Hexham Long Term Train Stabling Facility Modification 2 (SSI-6090-Mod-2) – Project Amendment

The purpose of this submission is to request that the scope of the modification to the approved State Significant Infrastructure Project for the Hexham Long Term Train Support Facility (LTTSF Project) (SSI-6090 – Mod 2) be amended prior to finalisation of the assessment. This modification is for the development of a depot, warehouse and wagon storage (the Modification Proposal) at the LTTSF, and has been submitted under Section 5.25 of the *Environmental Planning and Assessment Act 1979* (EP&A Act).

This Project Amendment has been prepared by Ethos Urban, on behalf of Aurizon, and is accompanied by Revised Modification plans provided in **Attachment A**, and a revised Landscaping Plan provided at **Attachment B**.

DRAWING TITLE	STATUS
LANDSCAPE PLAN PROPOSED DEVELOPMENT Aurizon/Hexham Operation Depot HEXHAM	PRELIMINARY ISSUE NOT FOR CONSTRUCTION
PROJECT No. 2180	DRAWING NUMBER
AUR-E-LP01A-7490	REVISION

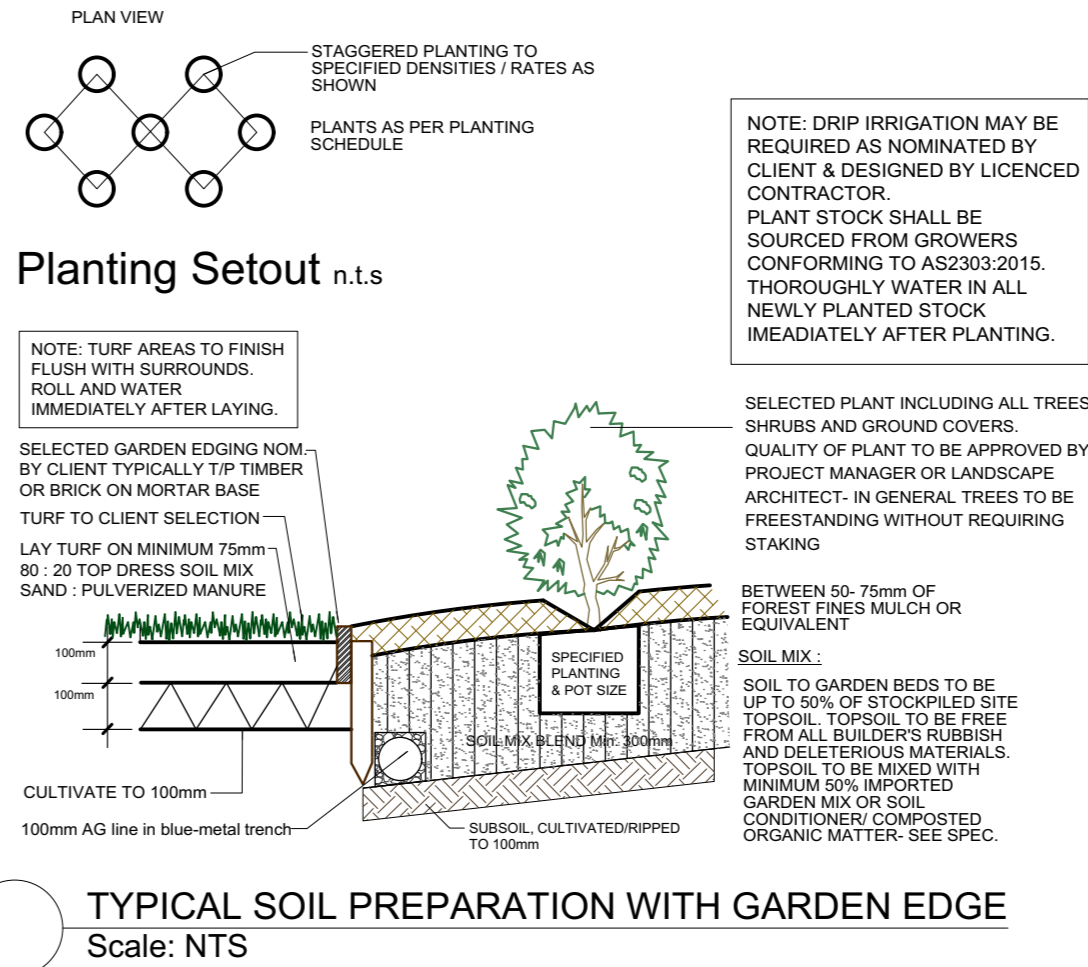
- The car parking area will be simplified, rationalised, and the total extent of hardstand reduced, whilst providing for 71 car parking spaces, including 3 accessible spaces, and 5 motorcycle parking spaces. Landscaping throughout the car parking area has been modified as part of the revised car park design, and a revised Landscaping Plan is provided at **Attachment B**.

DEPOT - GENERAL ARRANGEMENT PLAN

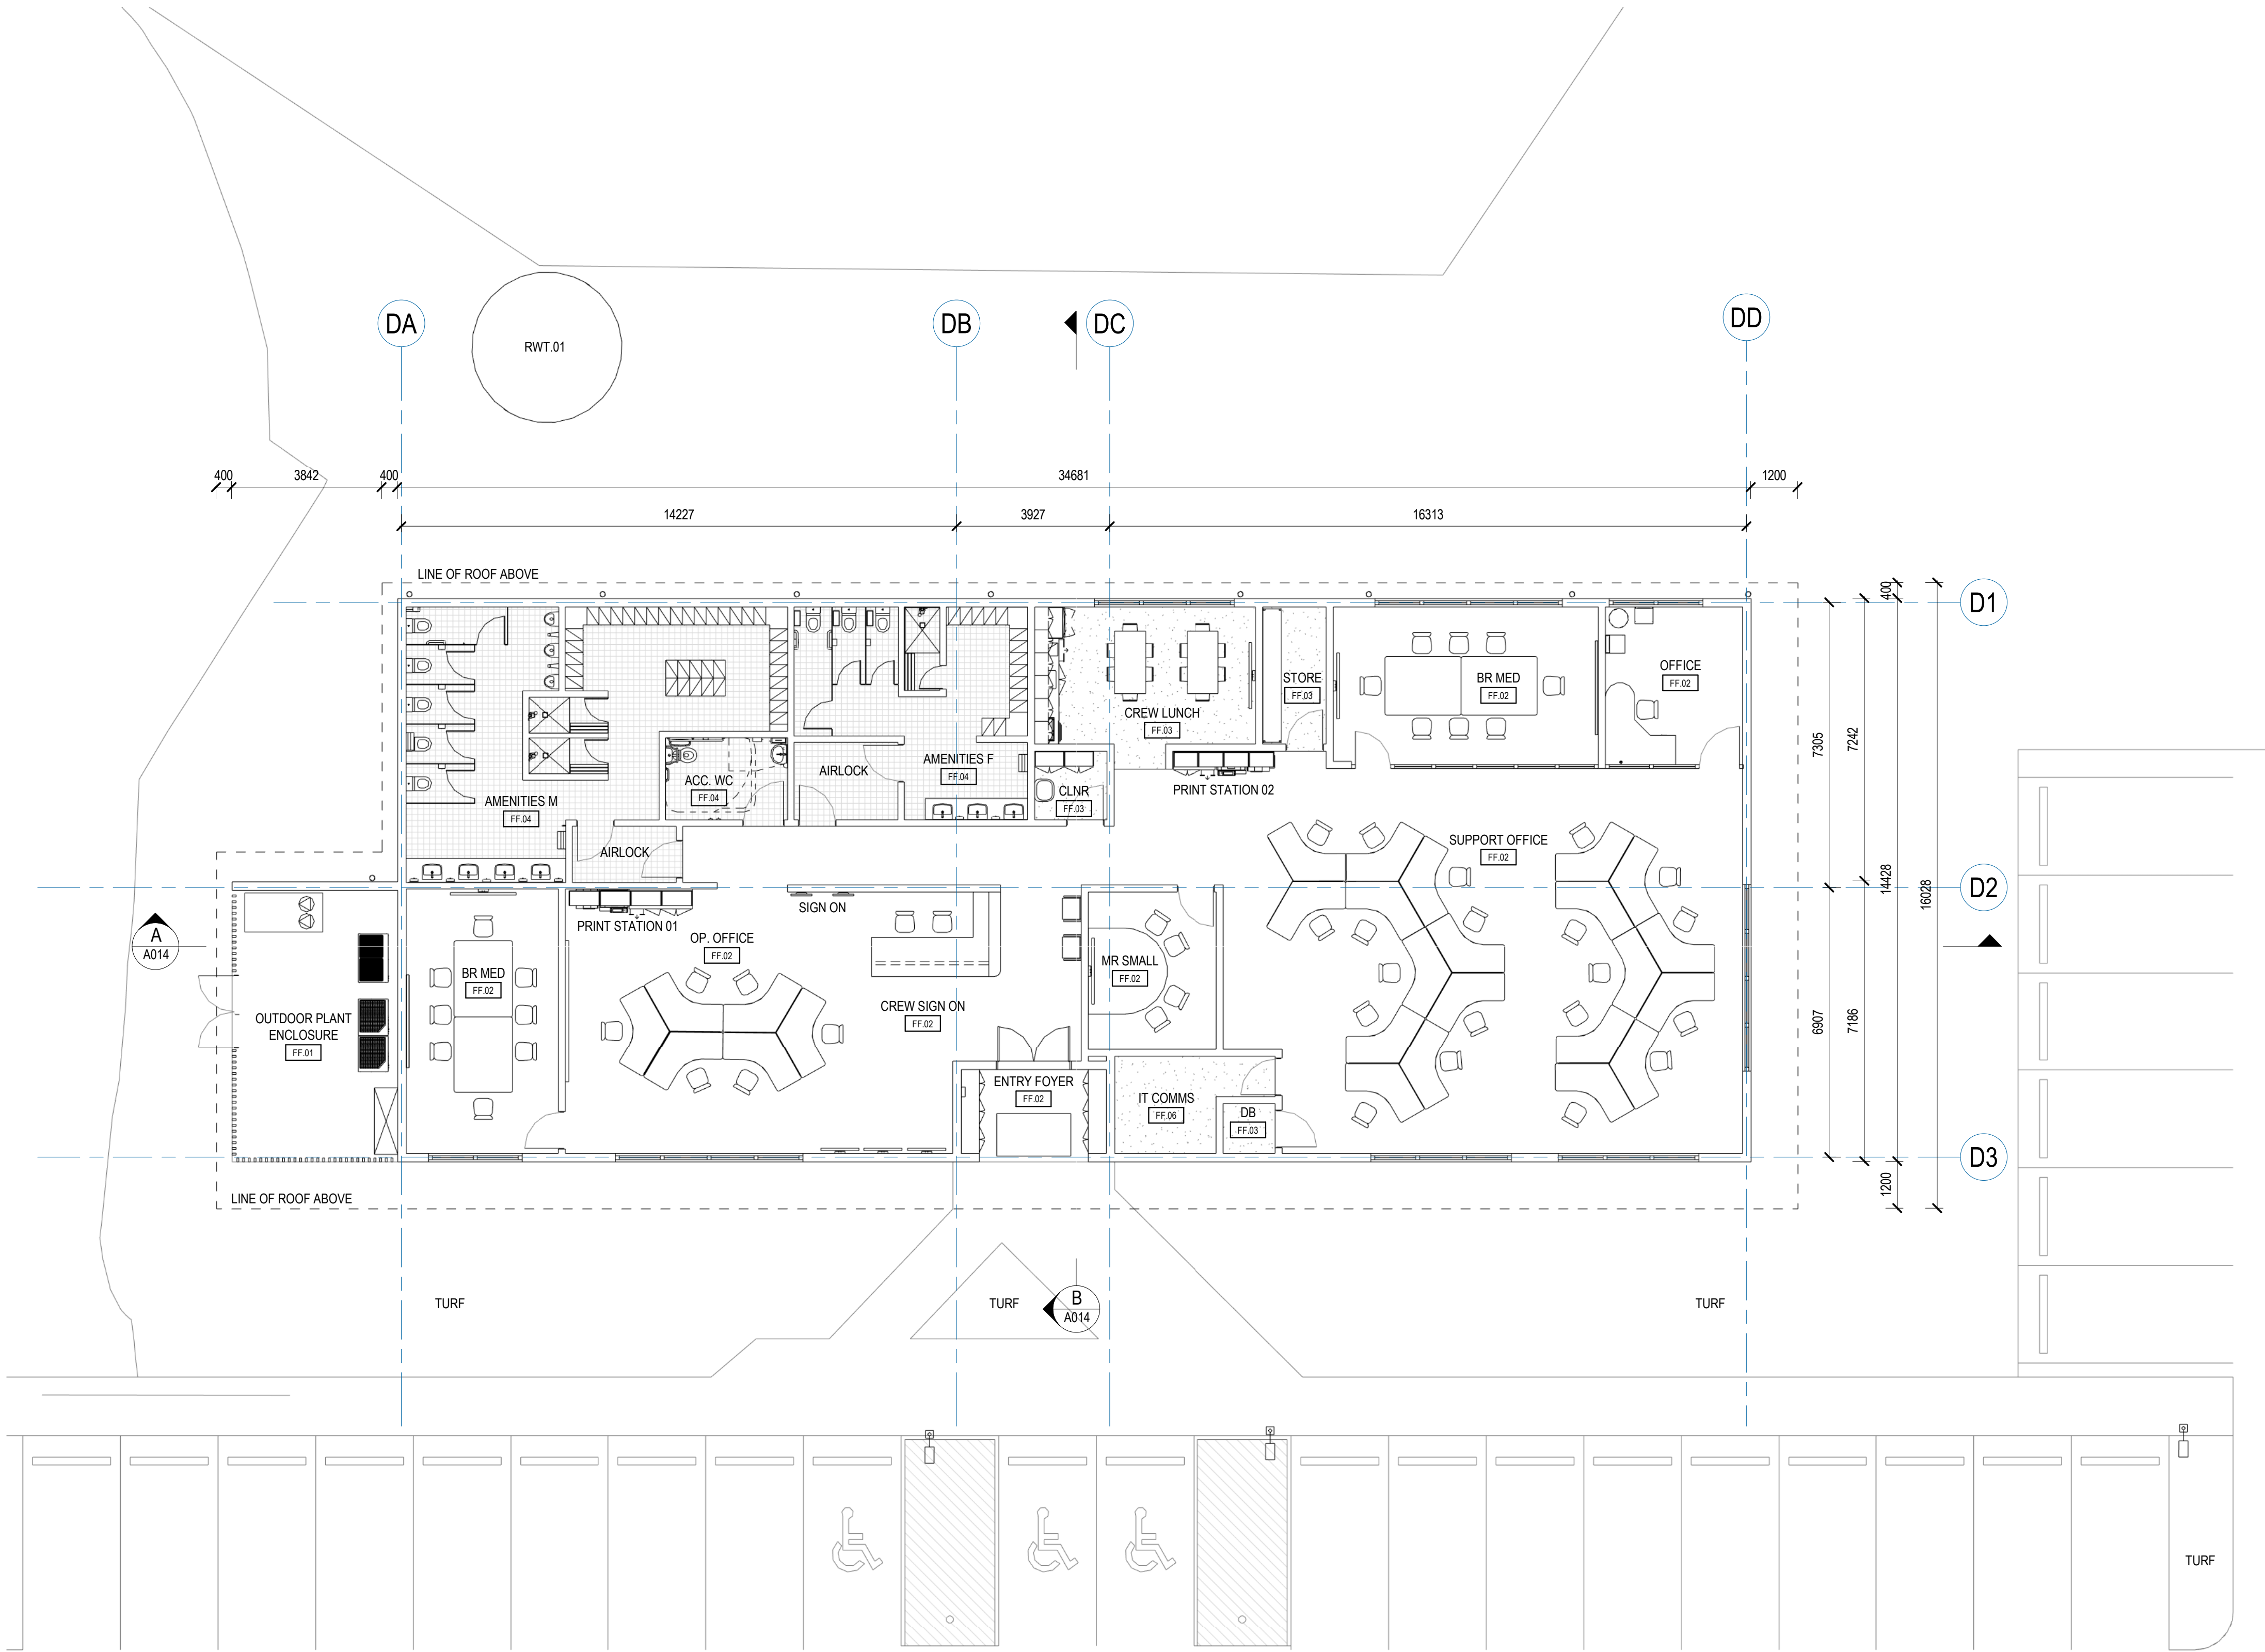
- The depot / office building will be reduced to 500m² with a simplified entry foyer. The height of the building will also be reduced to approximately 4m. Changes to the materials and finishes, although the building will still be finished with a combination of fibre-cement sheeting and colourbond steel.

DRAWING TITLE		STATUS	
WAREHOUSE - GENERAL ARRANGEMENT PLAN		70% DETAILED DESIGN	
PROJECT No.		12560779	
DRAWING NUMBER		AUR-E-A026-7300	
		REVISION	
		F

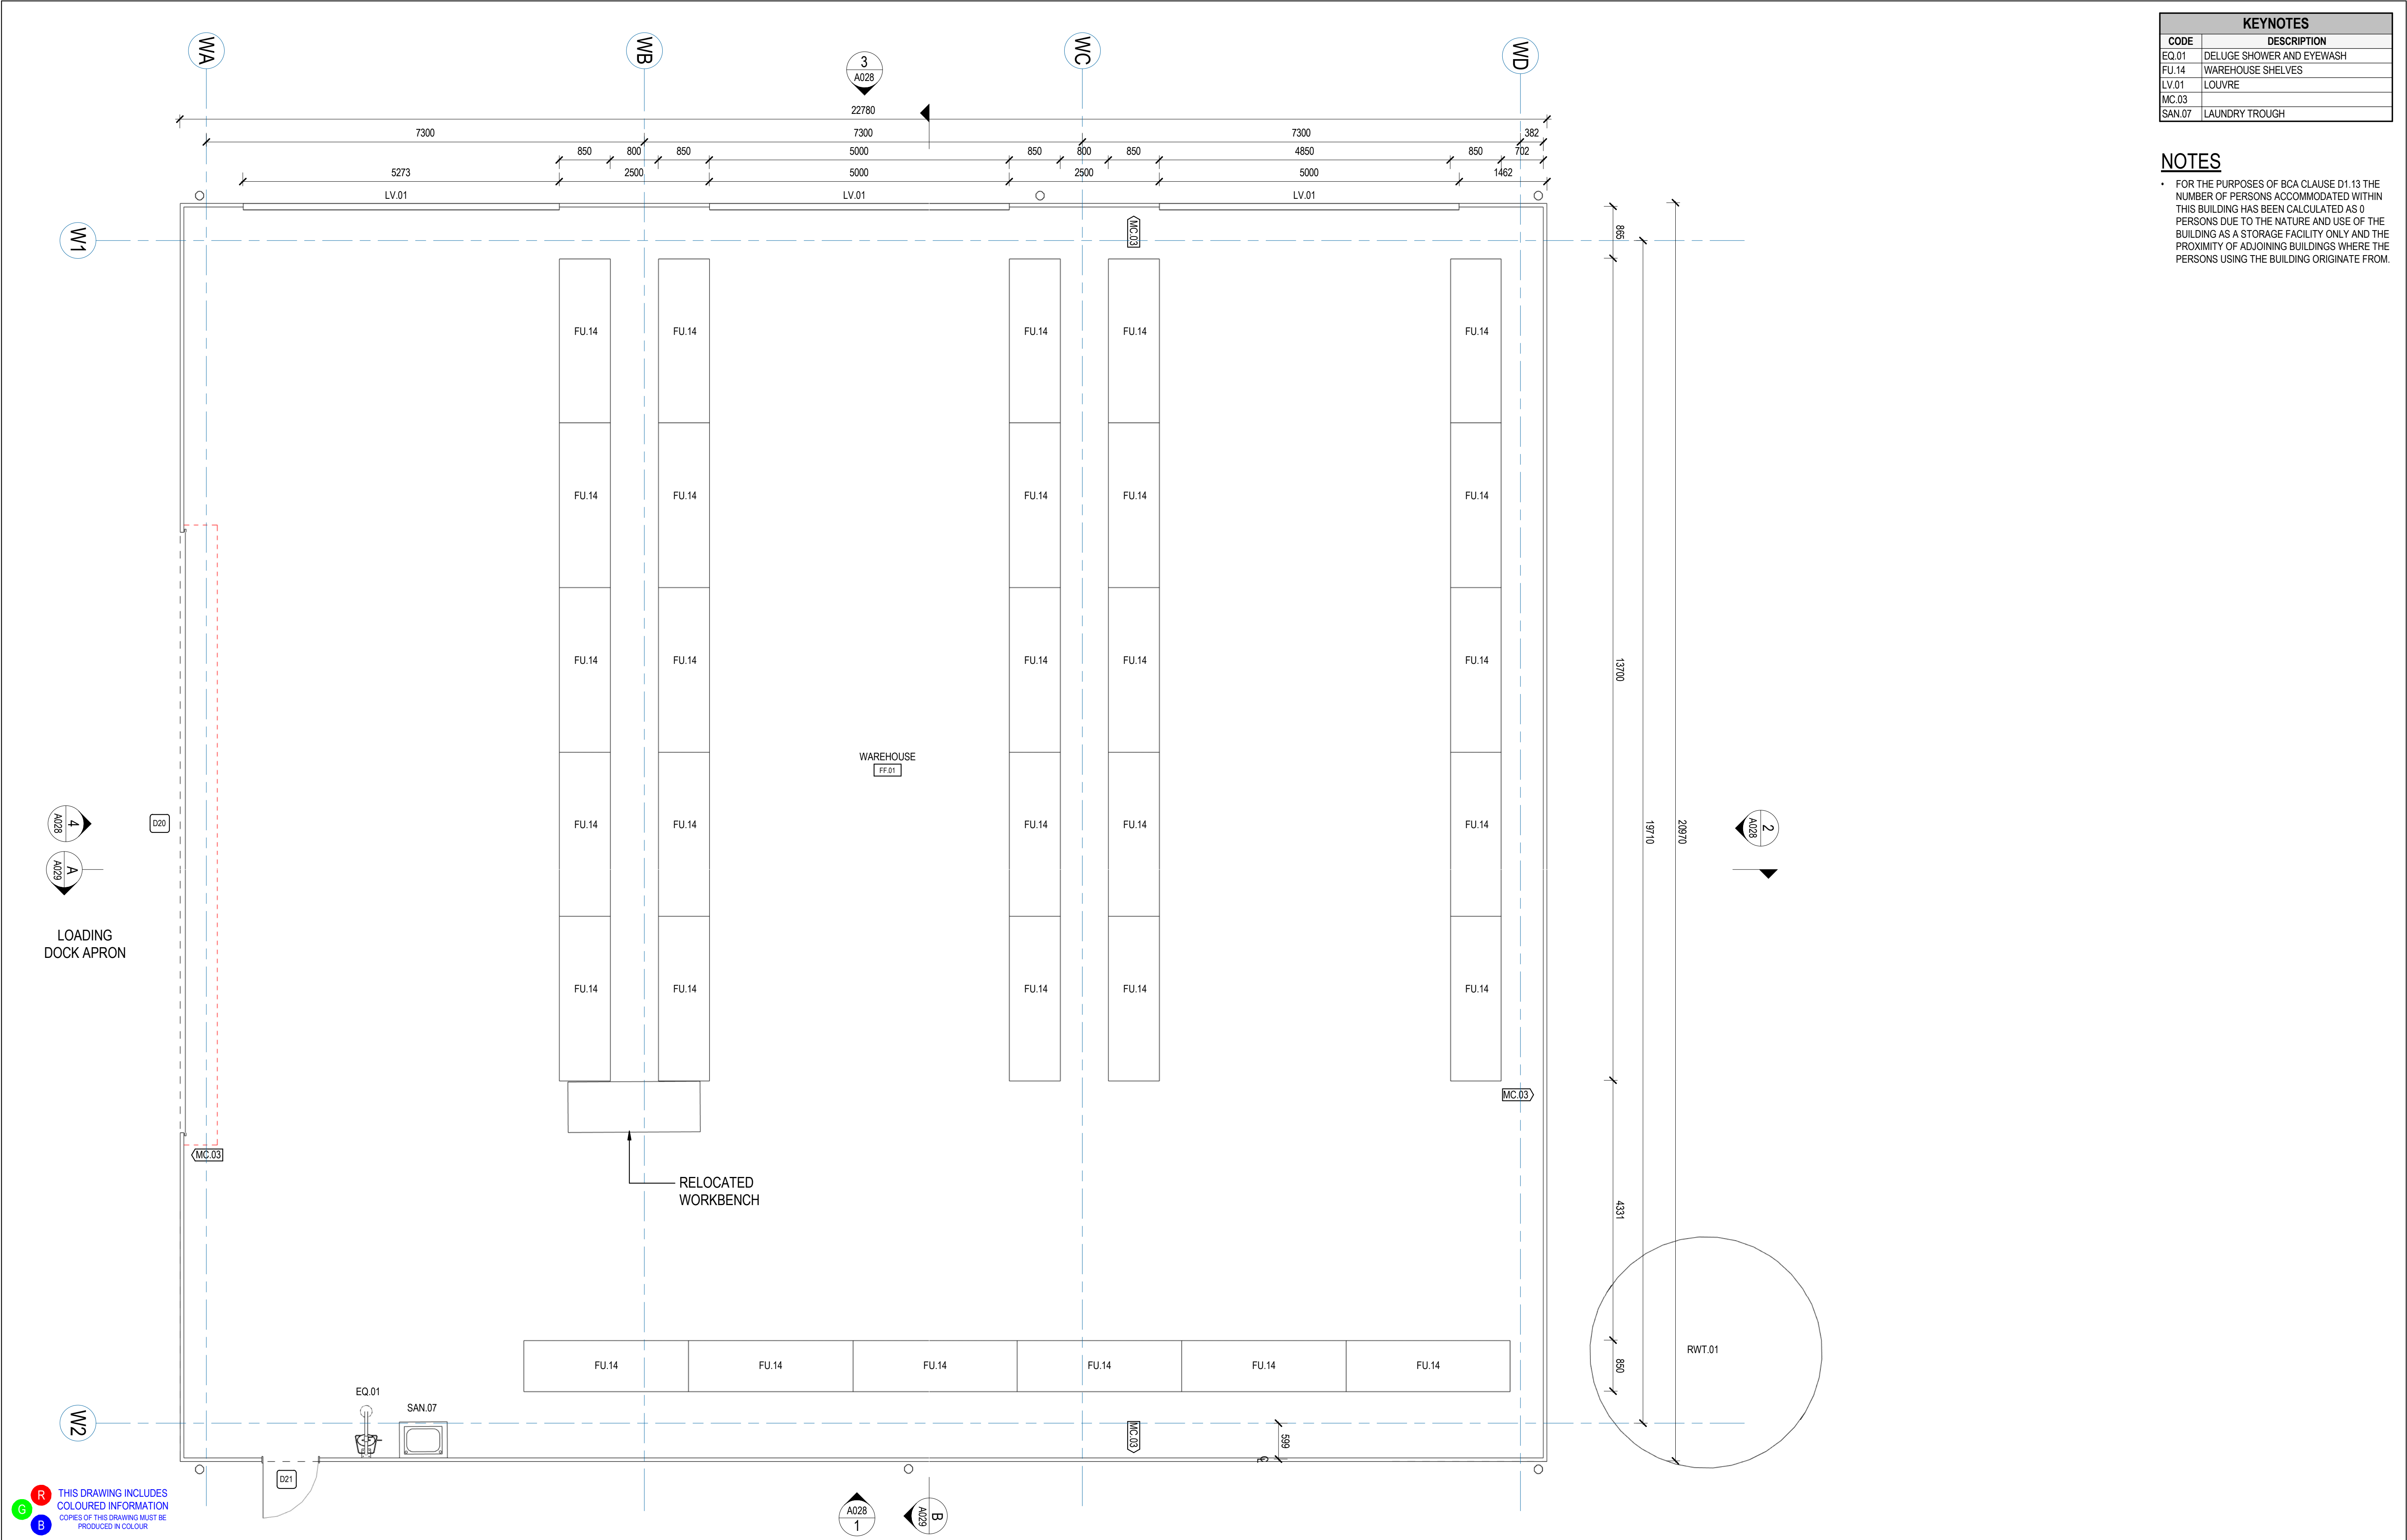
- The warehouse will be reduced in height from 12.3m to 10m. Changes to the materials and finishes, although the warehouse will still be finished predominantly in colourbond steel. .
